TRANSPORTATION MEMORANDUM

State Highway 83 & Needles Subdivision
El Paso County, Colorado
P268

June 2026
Revised July 2026

**Figure 3**  
**EXISTING TRAFFIC**  
Volumes & Intersection Geometry  
AM / PM Peak Traffic Hour  
(ADT) : Average Daily Traffic

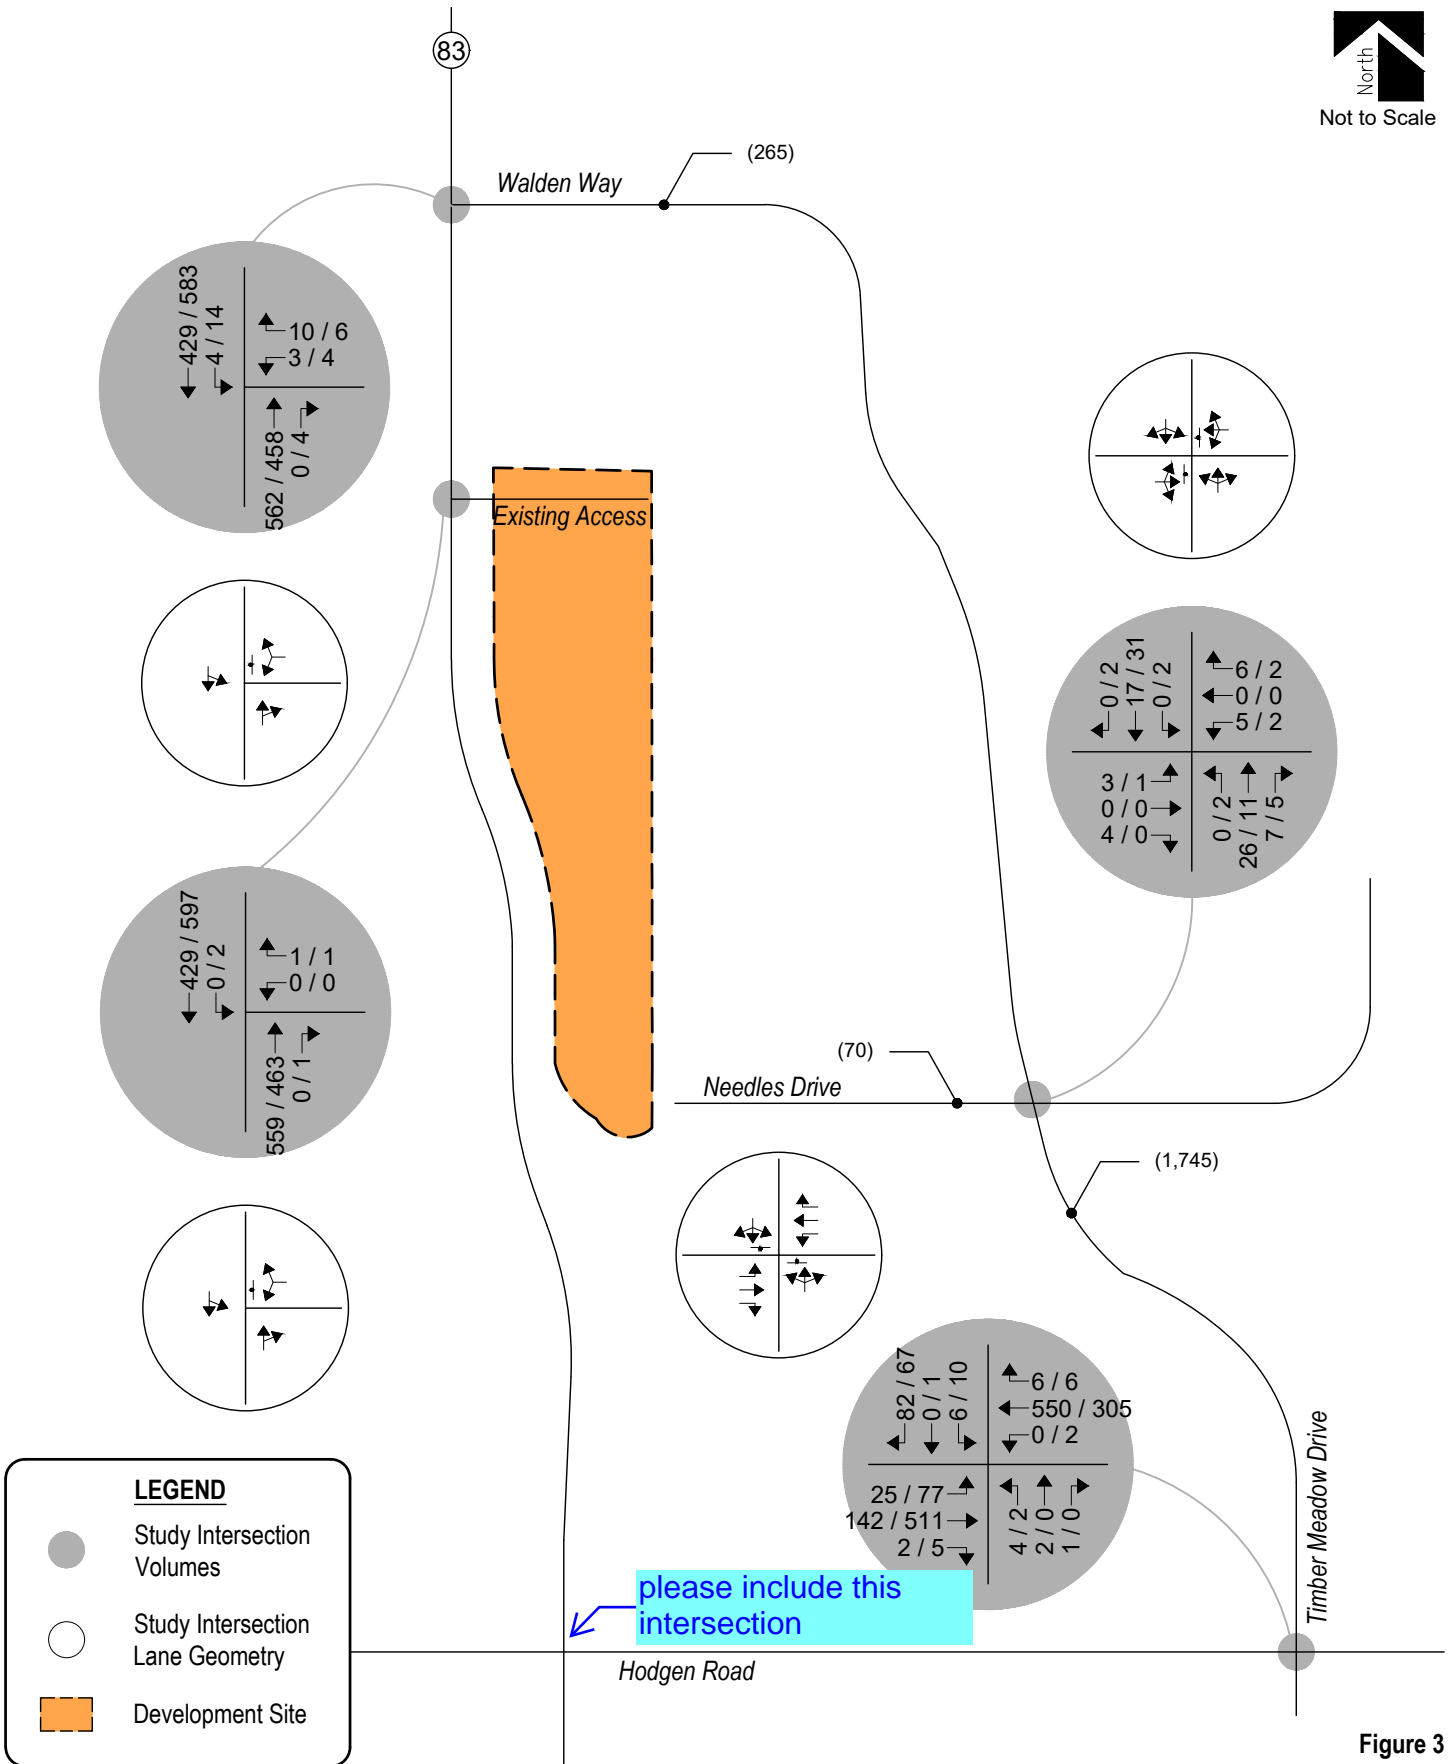
Analysis of this intersection was not included with PUDSP263. If volumes do not meet criteria for inclusion, please state the criteria in the description.

A statement is already provided on Page 1 satisfying this request. No revisions needed.
